V1_Traffic Impact Study.pdf Markup Summary

Prairie Ridge Rezones &

PCD File No. P2313, P2314, P2316 & SP239

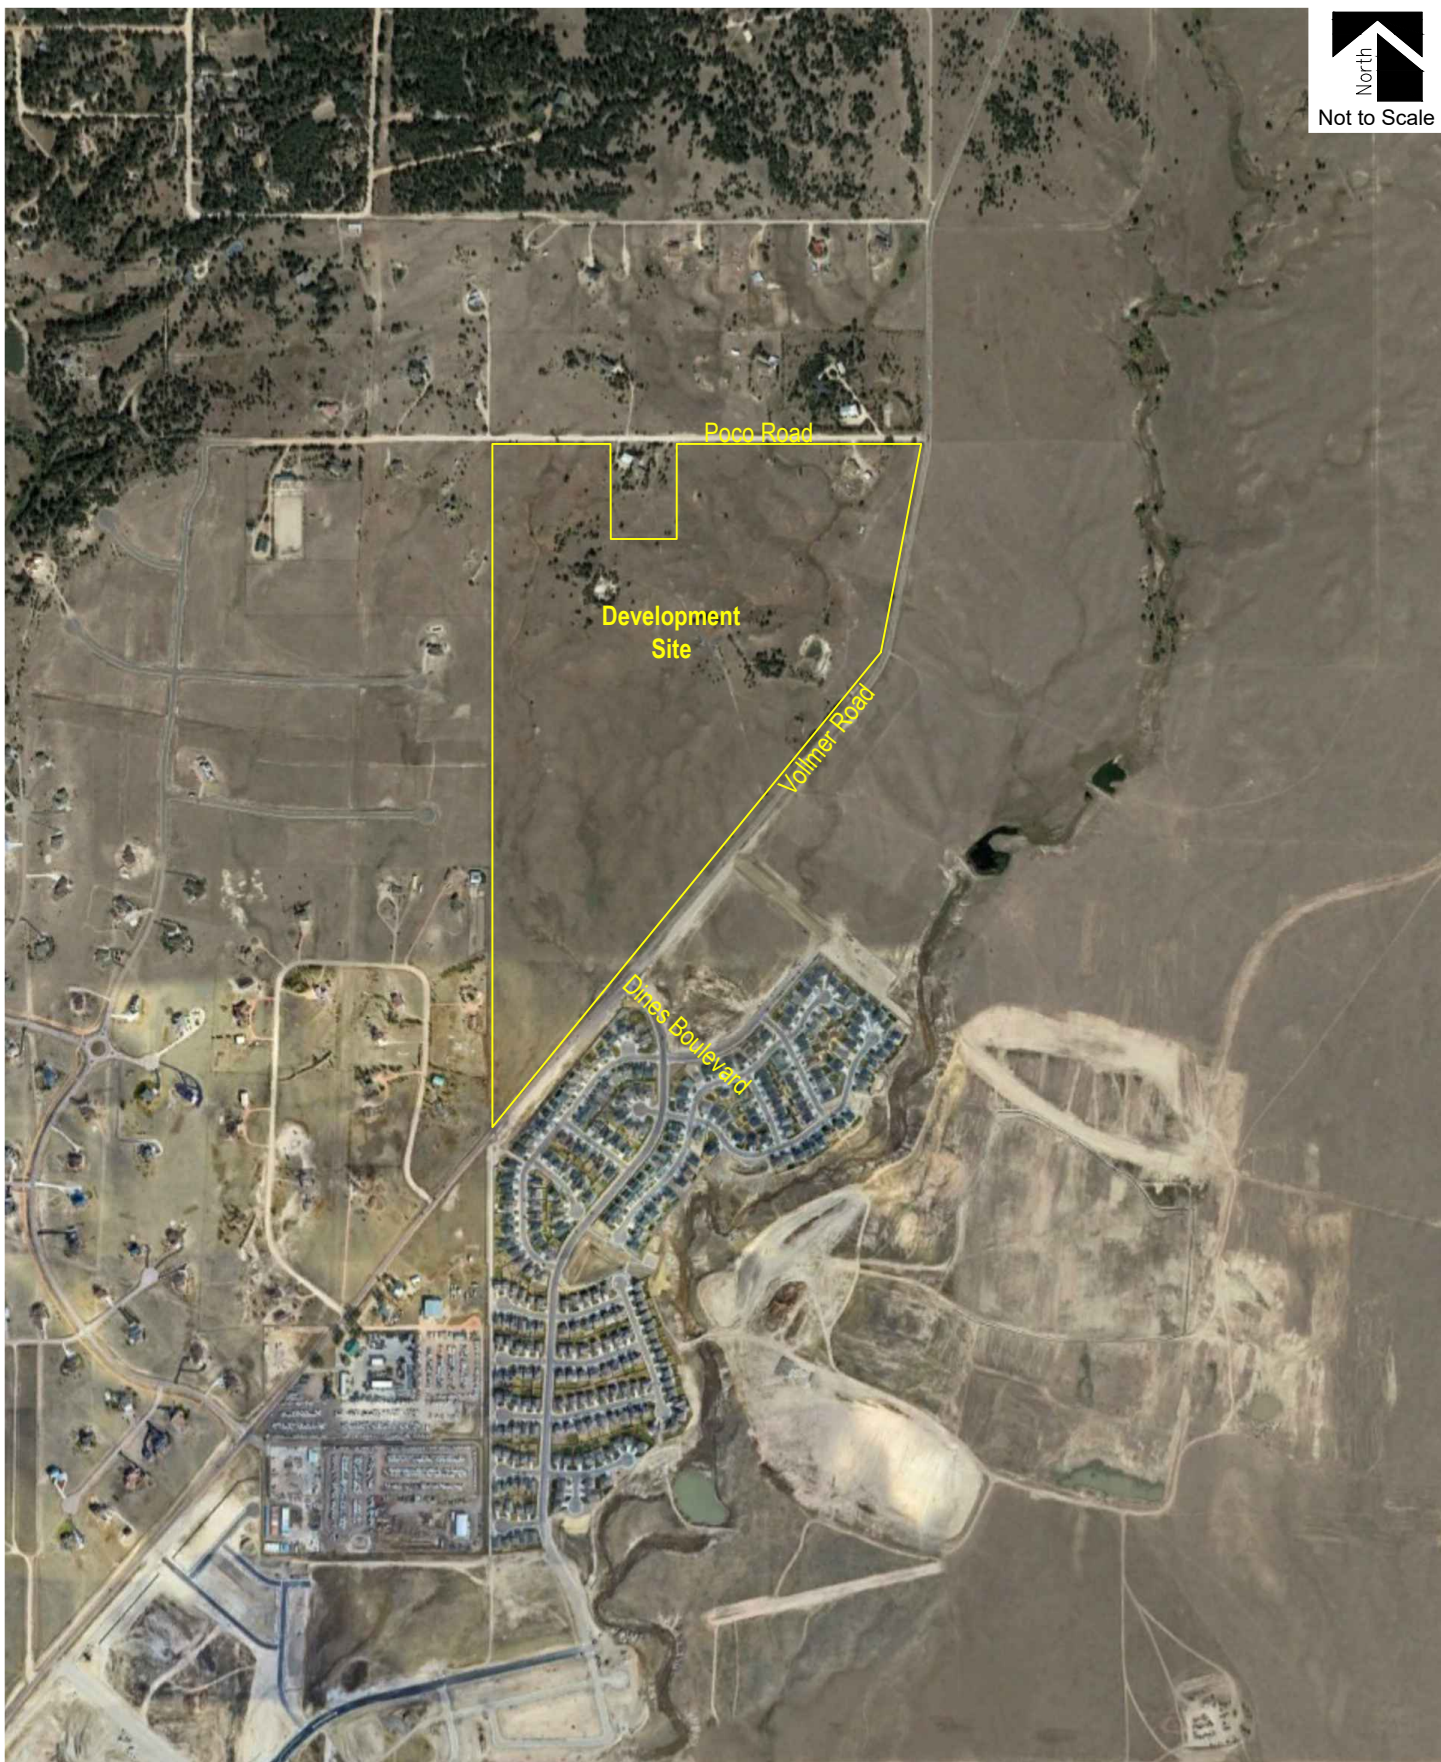
Add sight distance for every access and whether it can be met for proposed conditions.

**Figure 6A**  
**SITE DEVELOPMENT DISTRIBUTION - YEAR 2027**  
 (%): Overall  
**SITE-GENERATED TRIPS**  
 AM / PM Peak Hour

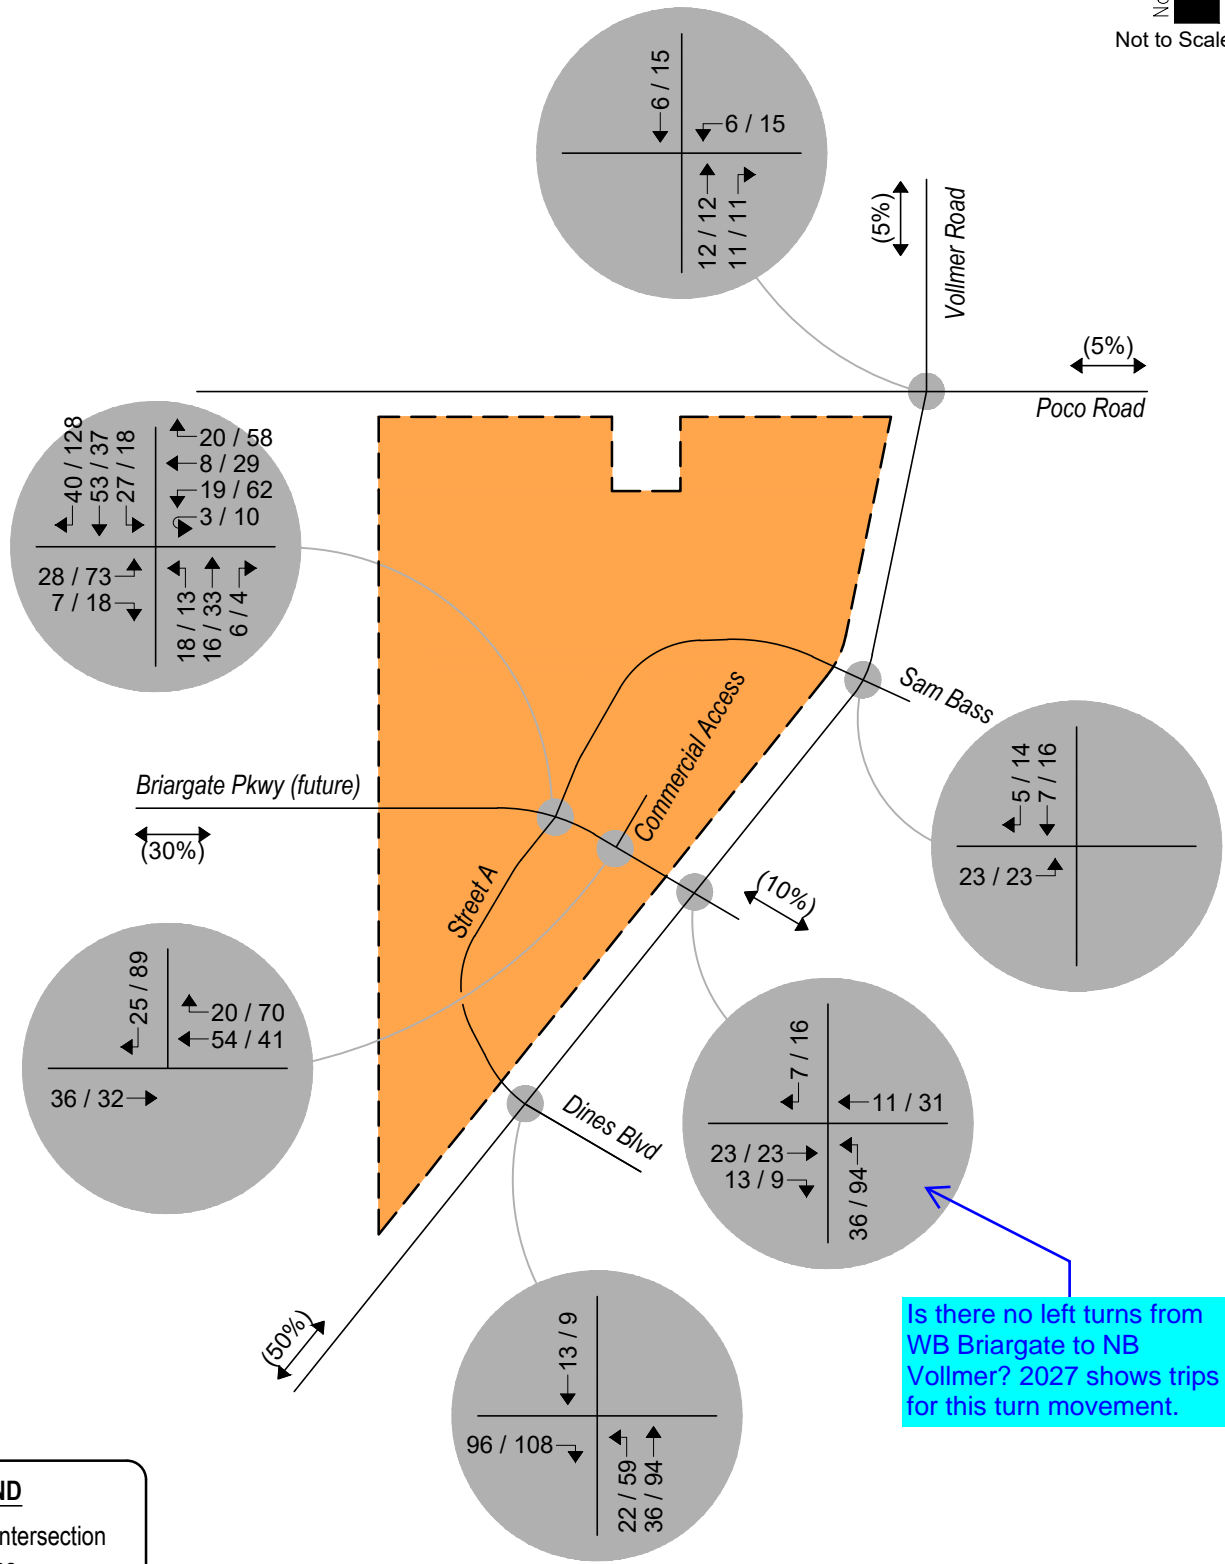
Is there no left turns from WB Briargate to NB Vollmer? 2027 shows trips for this turn movement.
